**BLOCK 4N CENTRAL PARK – Section 96 Submission
SUMMARY OF CHANGES**

20th January 2016

01 Cladding Type H3 - Typical Hotel Slot Facade - Section  
1:20

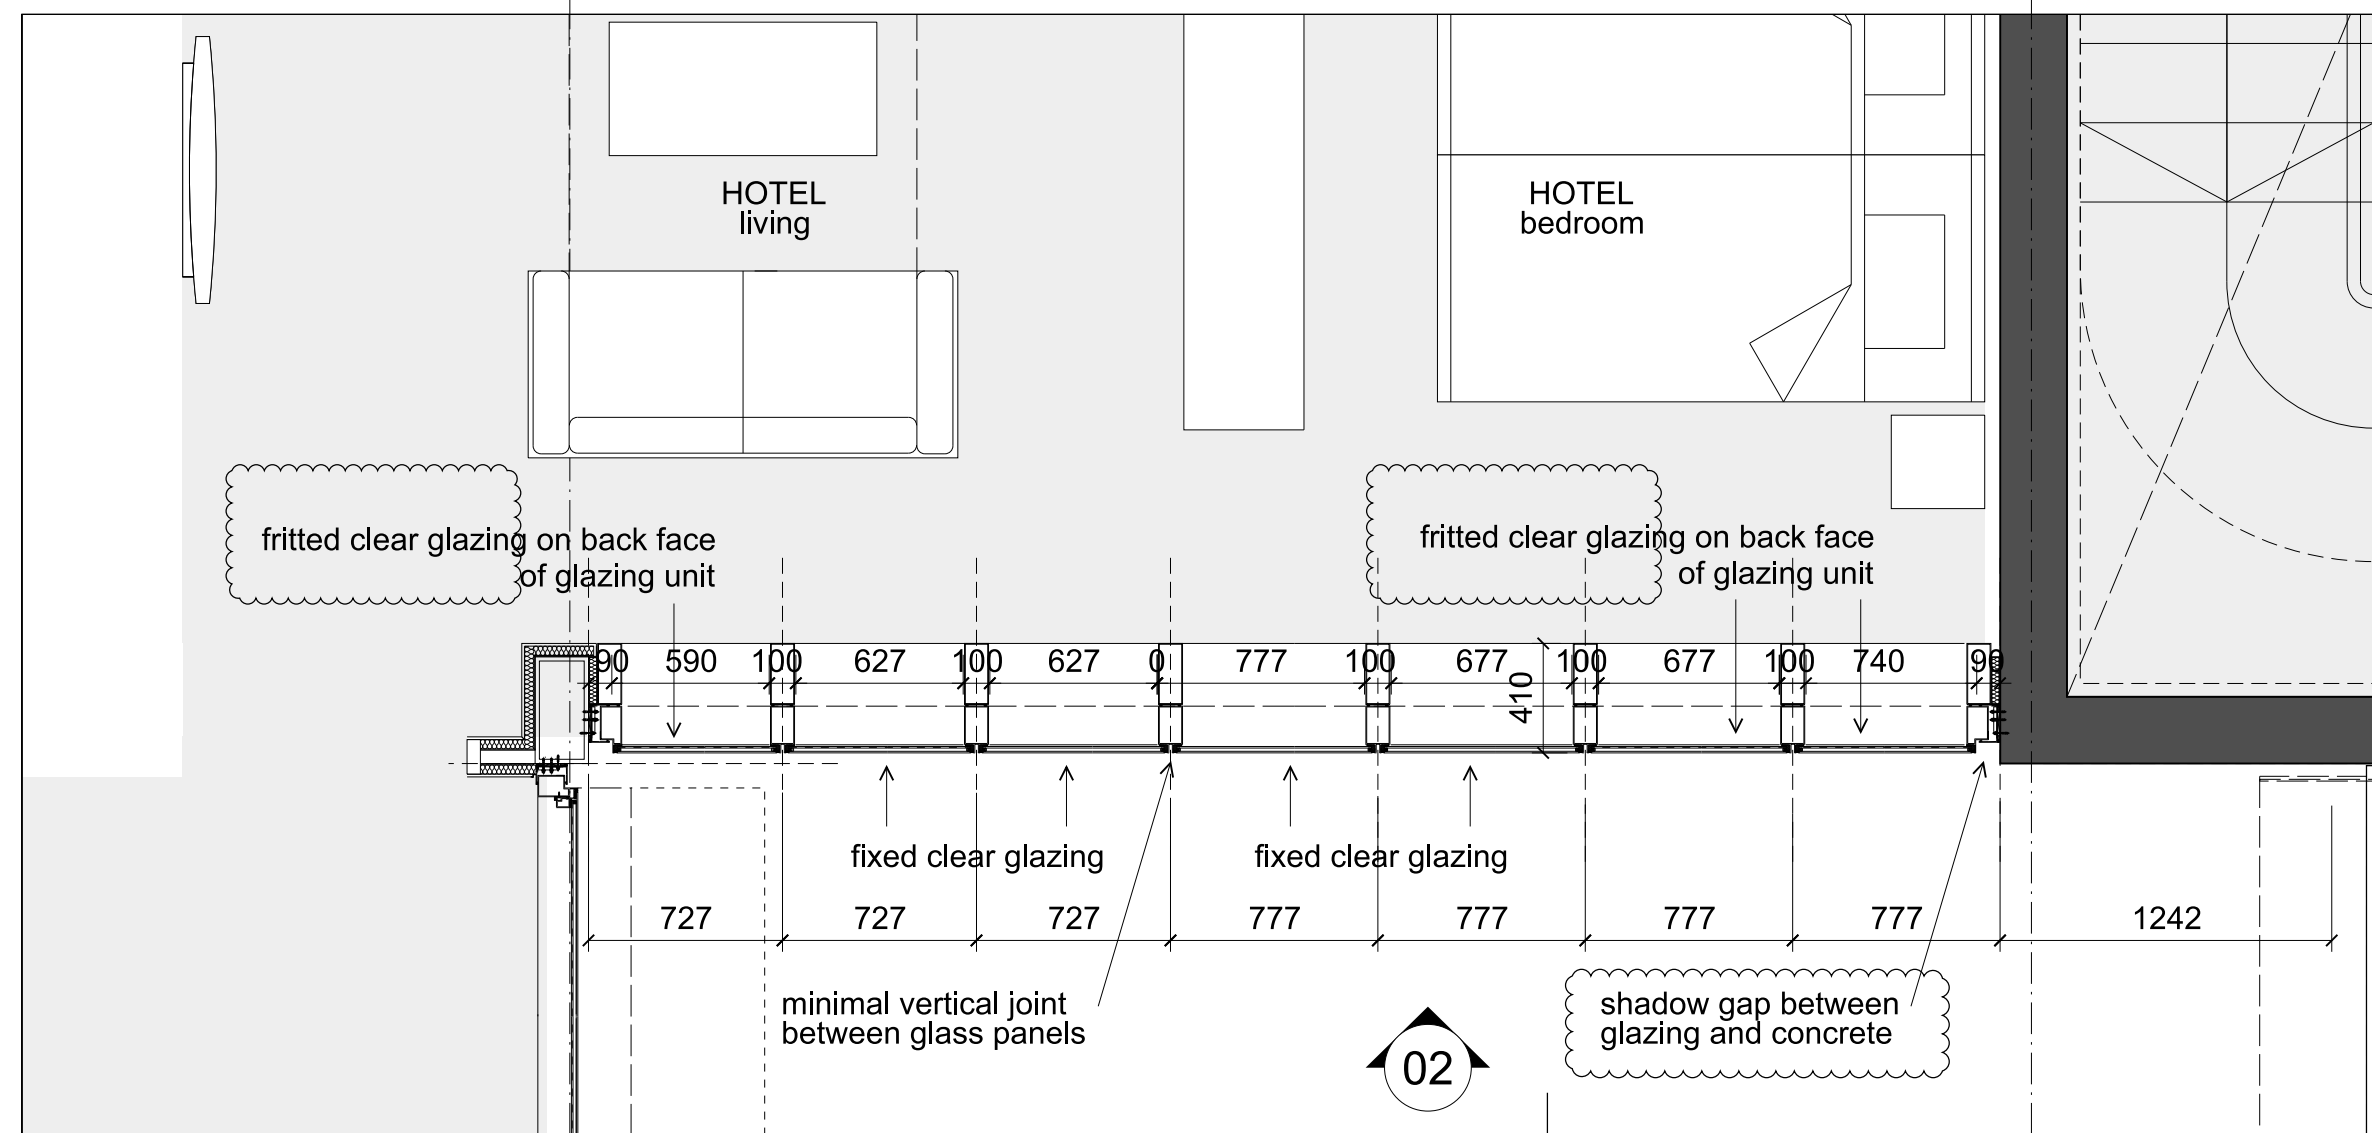
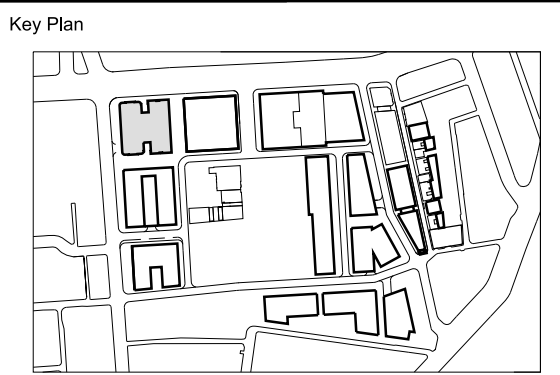
- Frame around the hotel units has been slightly reduced in depth (by 75mm)
- Podium facades elements such as clear glass zone, sunshades and spandrel panels have been slightly re arranged in order to better suit the new hotel operator brief within the podium levels

Block 4N
External Wall System
Typ. Childcare Balcony Facade
Cladding Type O2

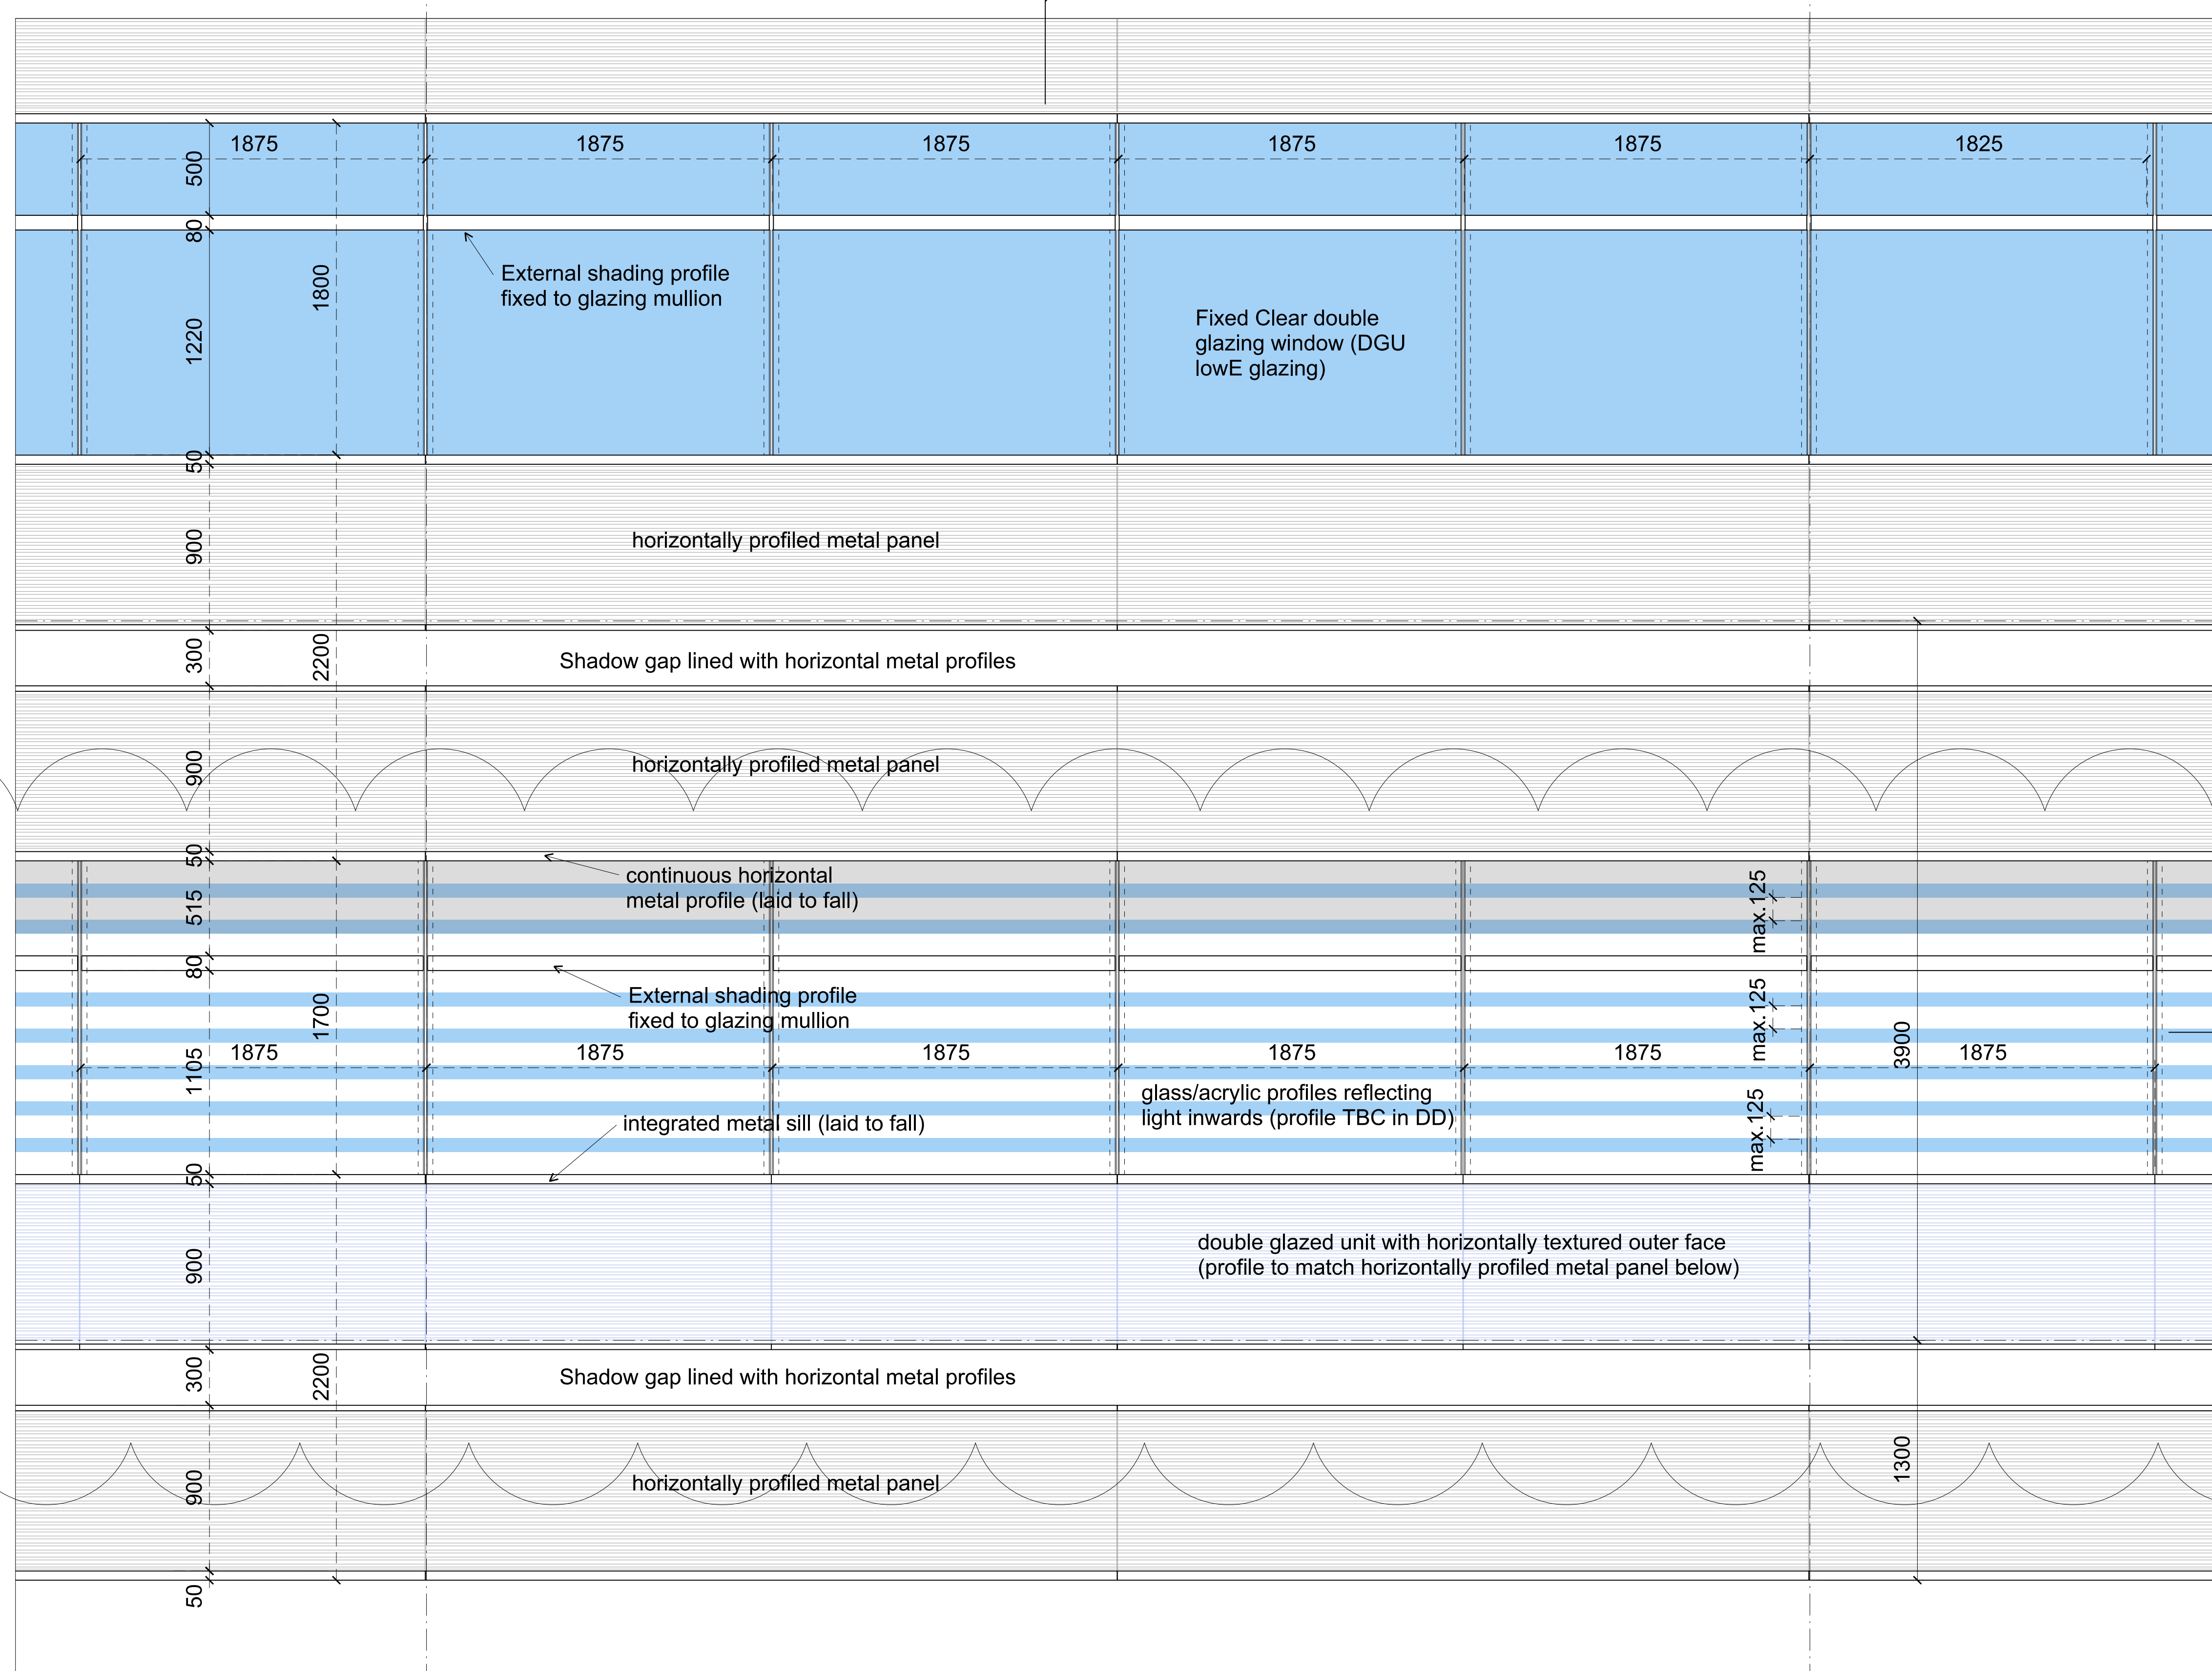
- The sunshade at high level of the commercial floorplates has been slightly reduced in height to now become 80mm high.
- Childcare Balcony façade has been revised from specifying glass tubes above the parapet to now becoming rectangular thick glass louver blades with a similar spacing.

Title:
BASEMENT 01 - GA PLANNING
CONDITIONS (BLOCK 4N)

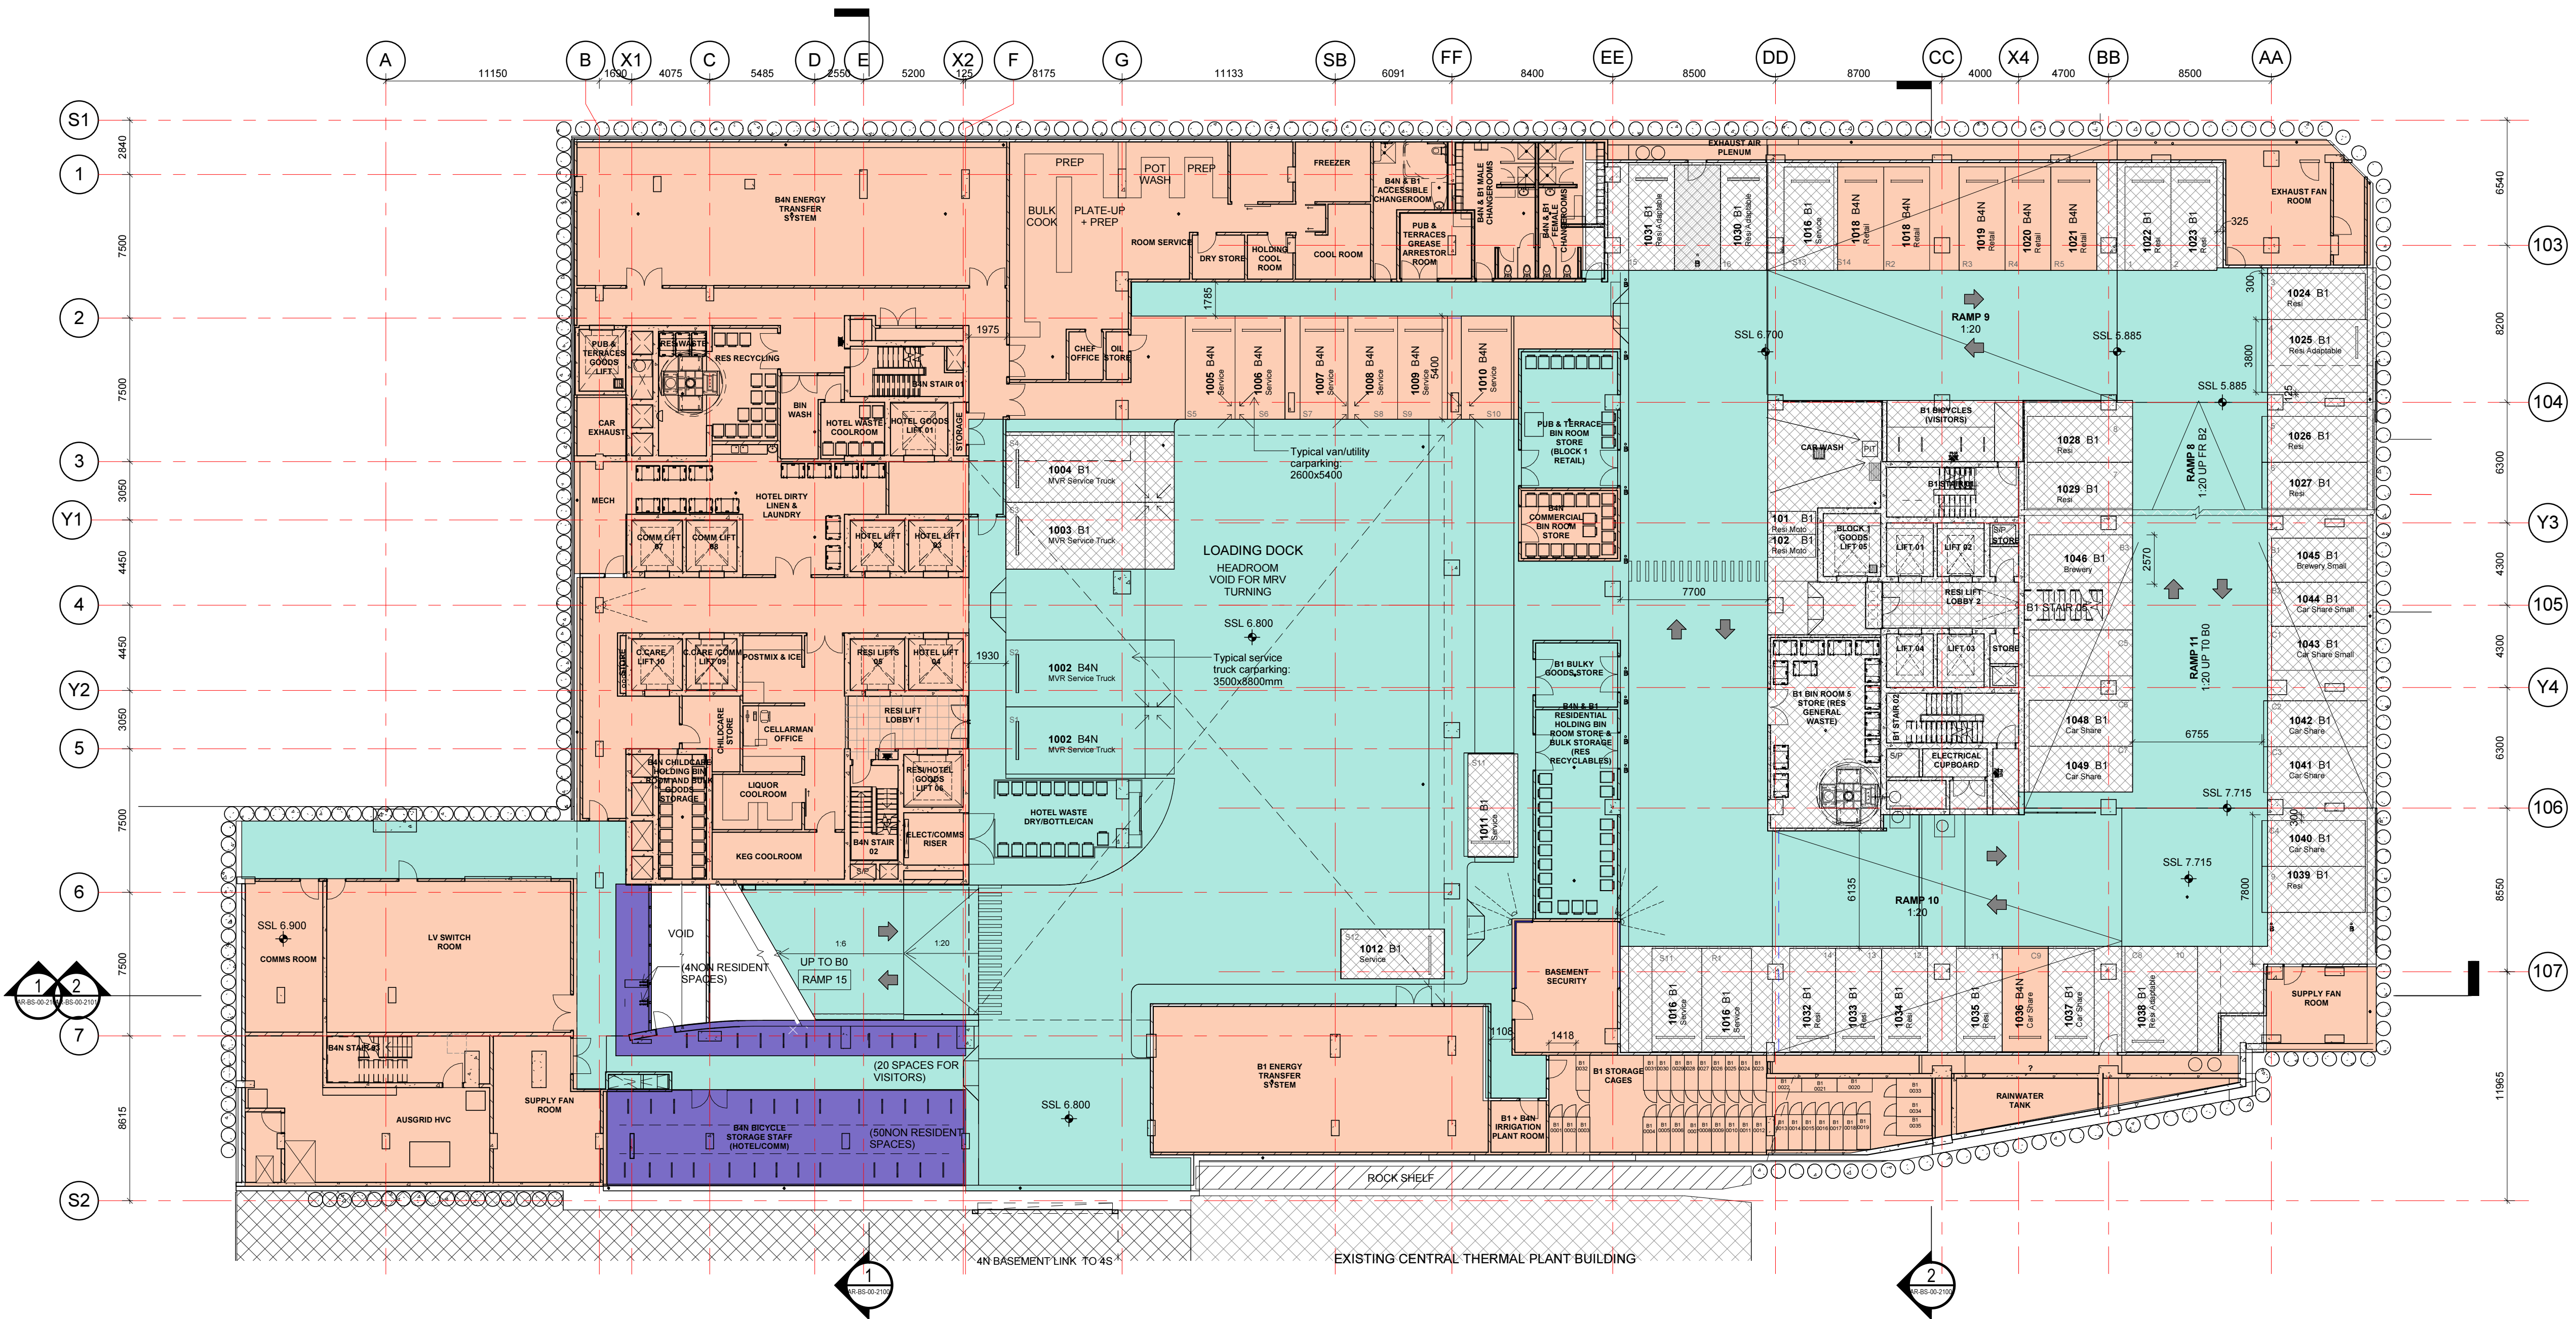
- The total number of hotel rooms is now 297 units, with a Luxury Suite integrated on the NE corner of level 17 and 18.
- The previous pool and hotel amenities on level 3 have been omitted and this floor has been redesigned to house more hotel rooms. This previous largely 'external' area has now become part of the internal GFA figures.
- Levels 1 and 2 now fully comprise of conference room facilities, break-out spaces, toilets, a kitchen and storage rooms
- The SW annex which earlier was used for commercial purposes has now been revised to become part of the hotel component, housing a small gymnasium, toilets and admin offices
- A re-numbering of the residential floors has been implemented to make them align better with the hotel floor numbering.
- Some amendments to the basement levels B00 and B01 have happened to incorporate additional hotel 'back of house'
